**WEST SUSSEX COUNTY COUNCIL
STRATEGIC PLANNING CONSULTATION**

SUBJECT: A/140/13 - Two storey rear extension to existing building with dormer to side of existing roof and new vehicular access and crossover to existing stables.

Brackenside, Dappers Lane, Angmering, West Sussex, BN16 4EN

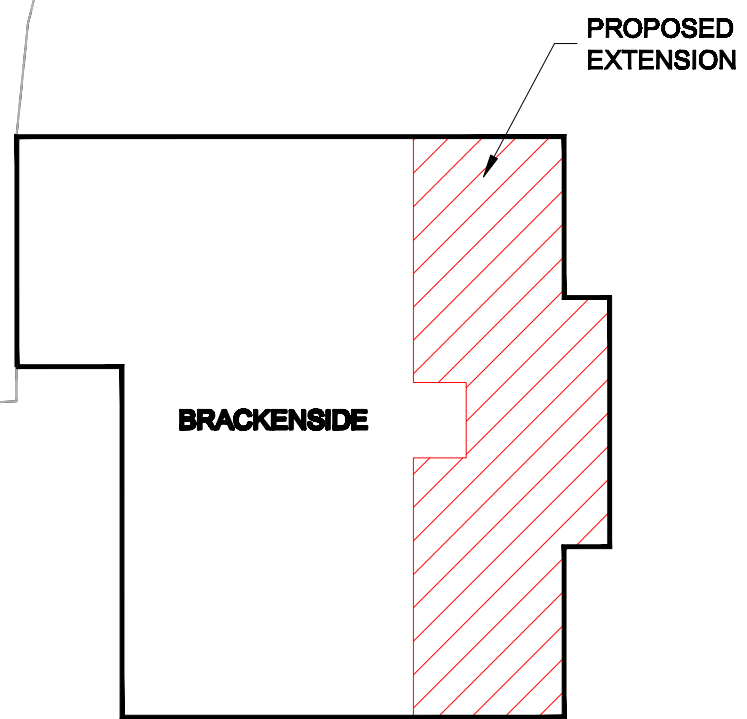
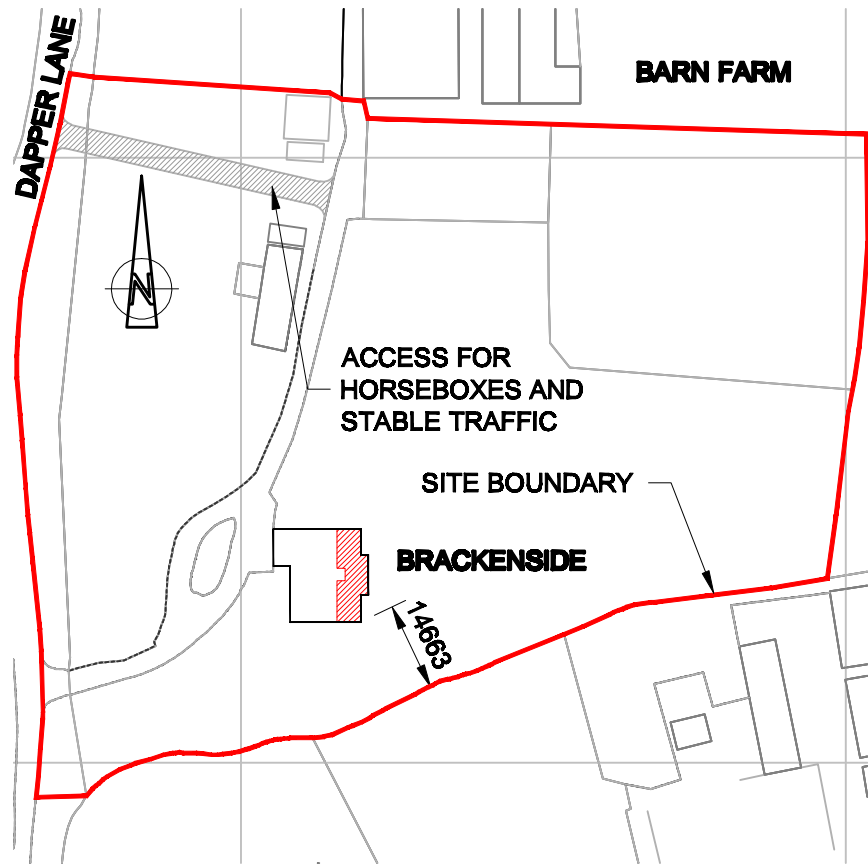
It is also proposed within the application to create a second access to the site to serve existing stables. However no information has been provided stating the width and what visibility can be achieved at the proposed point of access in each direction. This part of Dappers Lane is a National Speed Limit zone, therefore allowing vehicles to reach speeds of 60mph. In this instance, visibility site lines of 2.4m x 215m will usually be sought with no obstructions over 0.6m. However, as this road is fairly restricted in width and with the addition of the 30mph zone further south, it may be that speeds do not reach 60mph. If the applicant cannot show visibility sight lines of 2.4m x 240m then a speed survey may want to be considered to show the 85th percentile speed at the proposed point of access and then we or the applicant can calculate shorter visibility sight lines that can be achieved and conditioned.

Therefore before WSCC can be in support of this application, we would first require more information regarding the access and more specifically the site lines that can be achieved in each direction. Please re-consult once this information is available.
